Your Ref: 06_0250 MOD 11
Our Ref: D18/7750
DA18102415724 AB

Part 3A/State Significant Development Application - Modification - Seaside Boulevard, Fern Bay

The New South Wales Rural Fire Service (NSW RFS) has considered the information provided and considers that the proposal does not satisfy the aims and objectives of 'Planning for Bush Fire Protection 2006' on the following grounds:

Figure 2: Limits of Seaside Boulevard, after Determination of Mod 9, Aug 2018

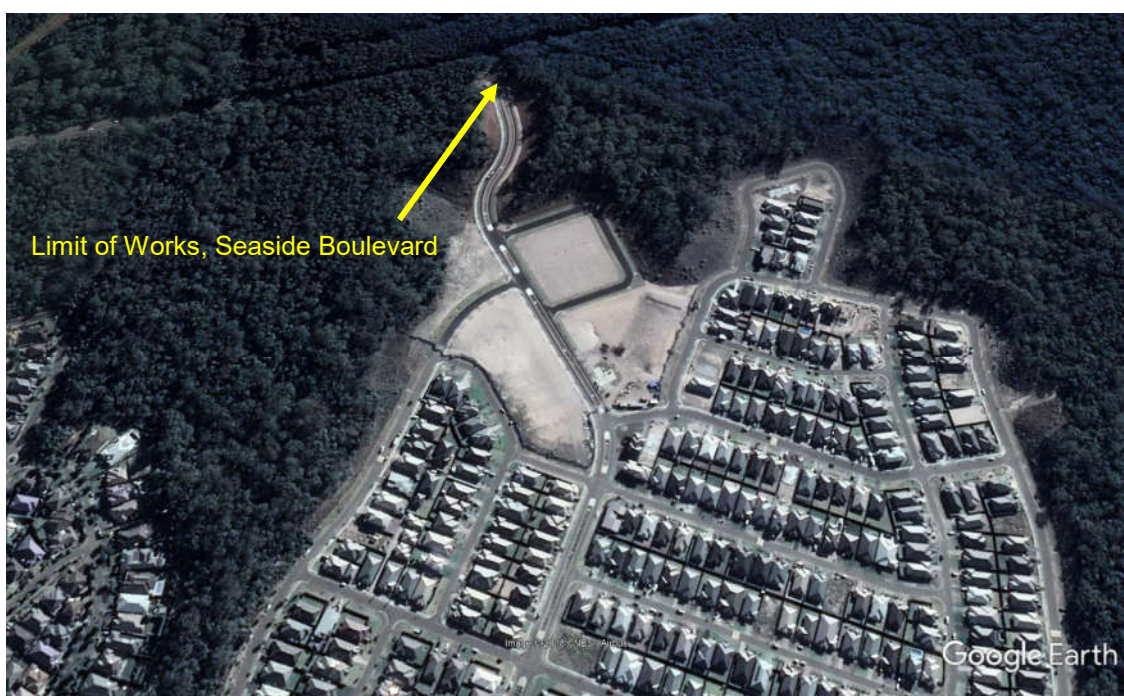
1. The application has not provided sufficient details on the commitment and timing of the construction of the required intersection to Nelson Bay Road. Stage 14 residential release was the trigger for the Seaside Boulevard roadworks including intersection works to be completed.
2. The application identified the current Nelson Bay Road access arrangements are suitable for emergency vehicle's to access Seaside Boulevard. A site inspection revealed overgrown vegetation and stockpiling of materials at this emergency access gateway. The MOD application will need to detail a minimum design standard for this to be used as a temporary emergency access.
